Council Reference: DA10/0853.09 LN20960  
Your Reference: MP 08\_0200 MOD 5

**Proposed modification of the Cobaki Project Approval  
(MP08\_0200 Mod 5) with regard to fencing and raptor nest  
requirements (Condition 39A and 39B).**

Figure 4: Raptor Nesting Platforms and Nest Locations

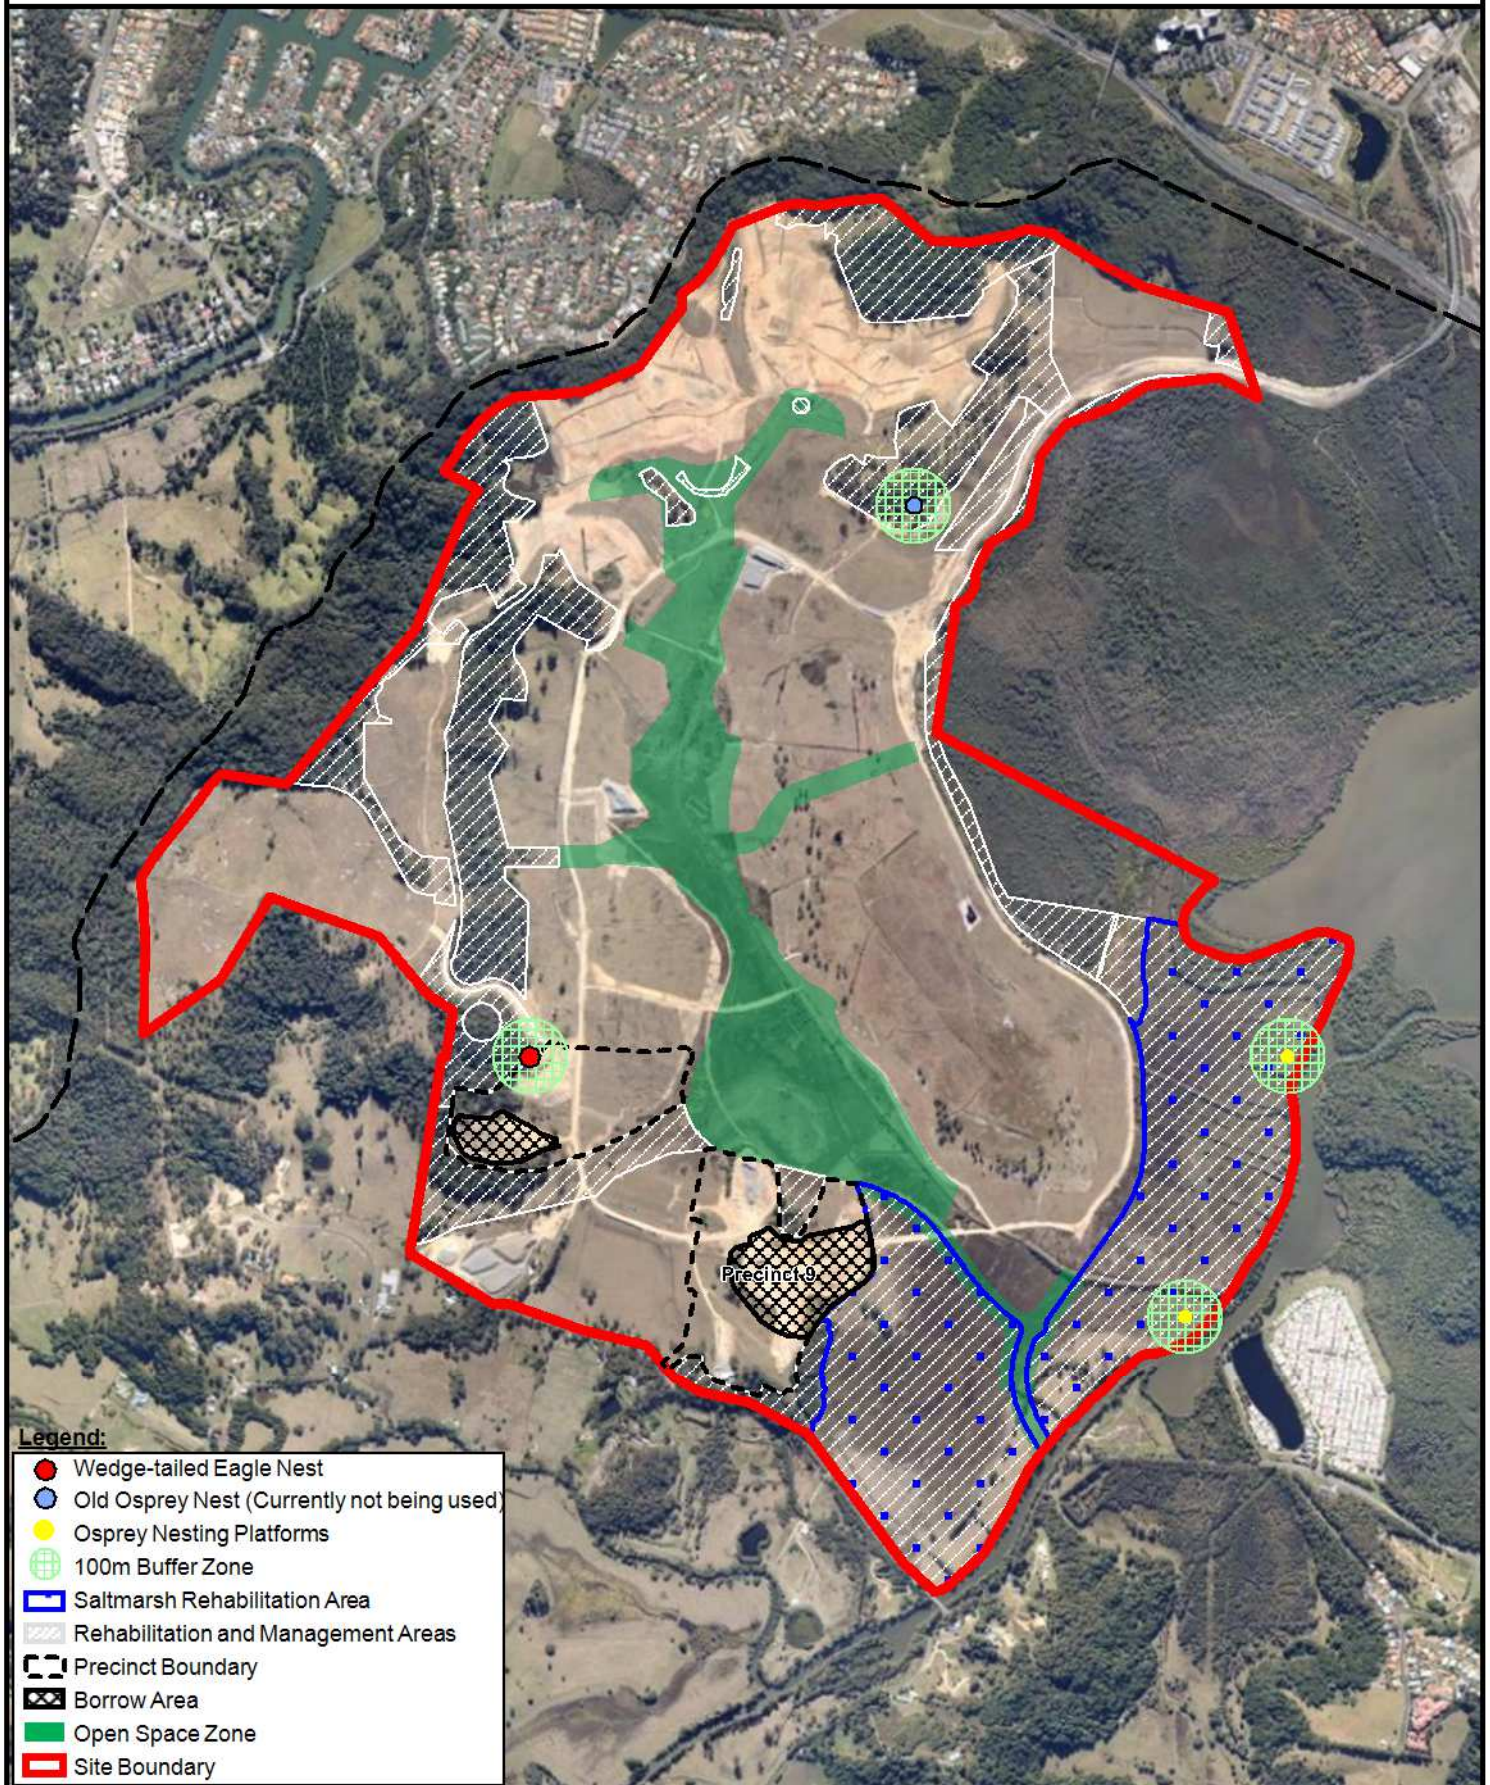
In terms of Condition 39A(b), whilst it is acknowledged that the Raptor nesting tree within Precinct 9 has not been utilised for some time, Council does have evidence of

previous use by Ospreys. It is considered appropriate that the 5m buffer fencing requirements be kept in place, to provide protection to the existing tree during construction works within Precinct 9. As such, the removal of Condition 39A(b) is not supported.

Although the proponent has identified the additional Raptor nest in Precinct 11 and applied a 100m buffer, it is not considered appropriate to remove the condition. Whilst it is recognised that the Raptor nesting site within Precinct 9 has not been utilised for some years, the tree remains in place as a possible nesting site. The 100m buffer provisions of Condition 39B only apply if the proponent's Environmental Officer identifies that the nesting site in Precinct 9 is being utilised. As such, it is not considered necessary to delete Condition 39B and the proponents request to do so is not supported.

Figure 5: Cobaki Estate – Approved Earthworks Fencing Plan – MOD 2

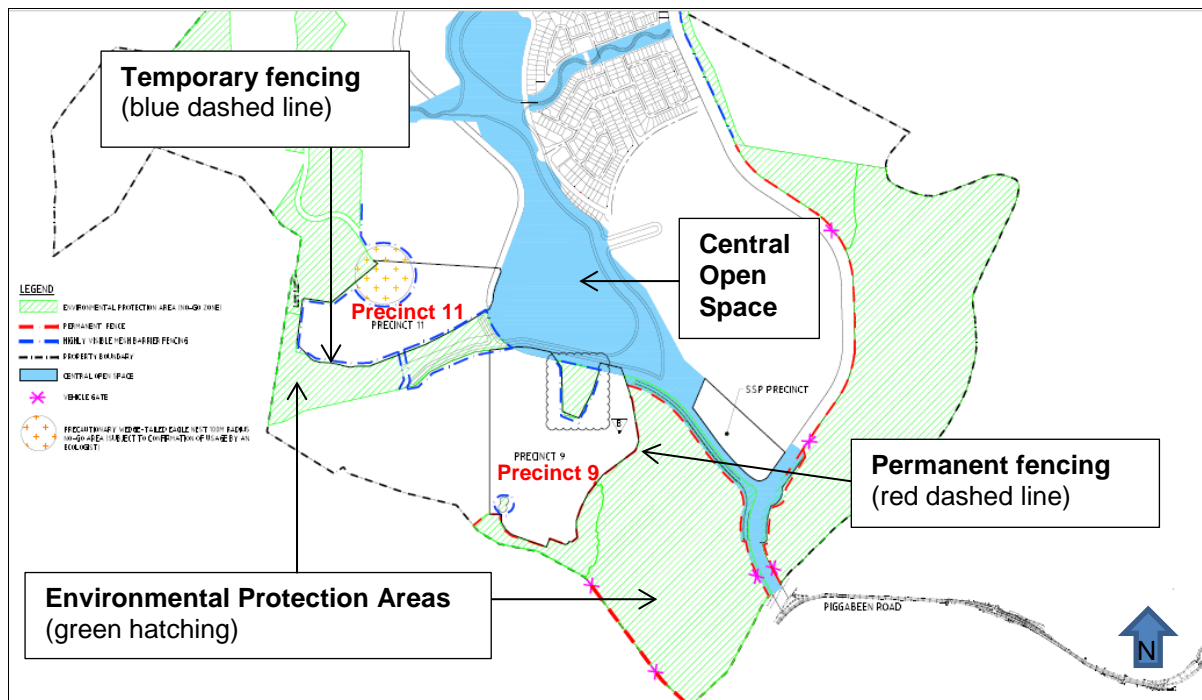
With respect to Condition 39A(a), Council recognises that the intent of the proposed Mod is to ensure that the fencing requirements only relate to earthworks activities within Precinct 9 and 11. Given that the proponent's revised fencing plan provides for protection of the environmentally sensitive areas adjoining Precincts 9 and 11, Council supports the proponent's request to clarify the temporary fencing provisions, as identified in Dwg 3310071E-044(2) Rev B. Accordingly, a modification of part (a) of Condition 39A, with similar wording to that identified above is supported.
